KITTITAS COUNTY DEPARTMENT OF PUBLIC WORKS

MEMORANDUM

TO: Jeff Watson, Community Development Services
FROM: Christina Wollman, Planner II *CW*
DATE: December 3, 2010
SUBJECT: McIntosh BL-10-00038

The Public Works Department has reviewed the Request for Boundary Line Adjustment Application. In order to ensure that it meets current Kittitas County Road Standards, the applicant needs to provide the following prior to final approval:

PART OF THE NORTH HALF OF SECTION 8,
TOWNSHIP 18 NORTH, RANGE 18 EAST, W.M.

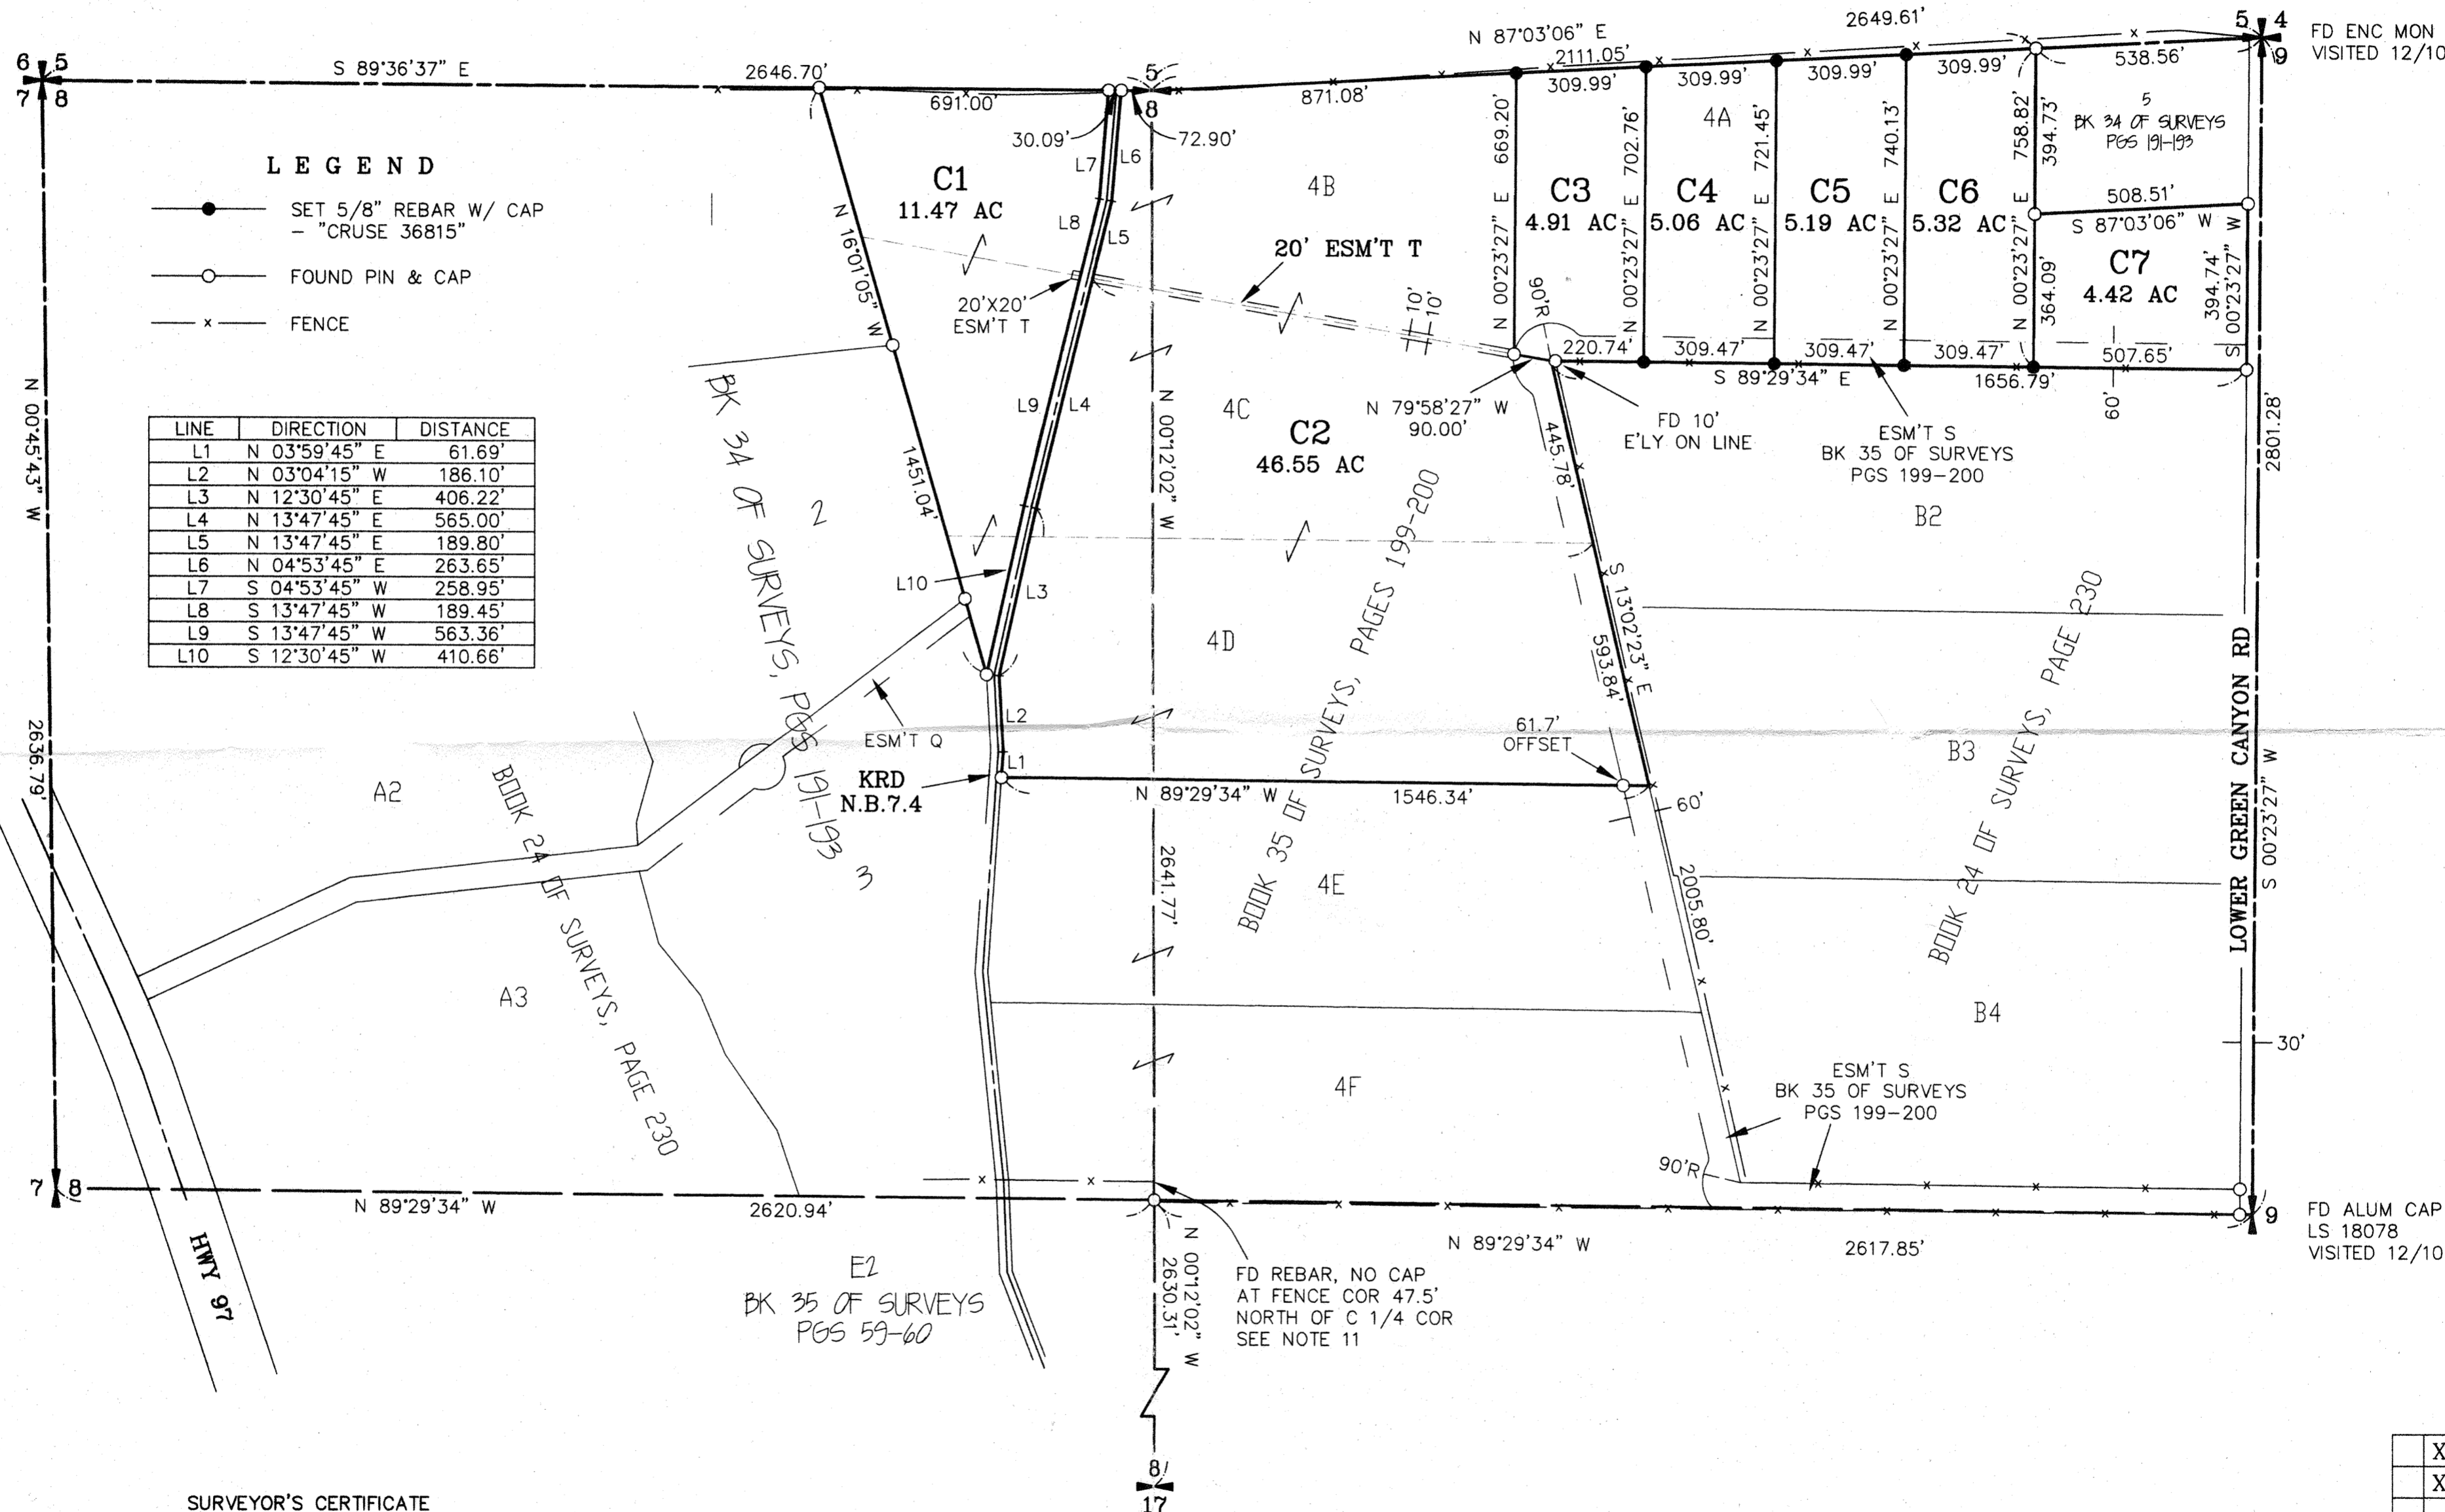
1. The proposed access with appropriate easement(s) shall be shown and shall conform to applicable Kittitas County Road Standards.
2. A revised legal description that describes the final configuration of the subject property shall be required.
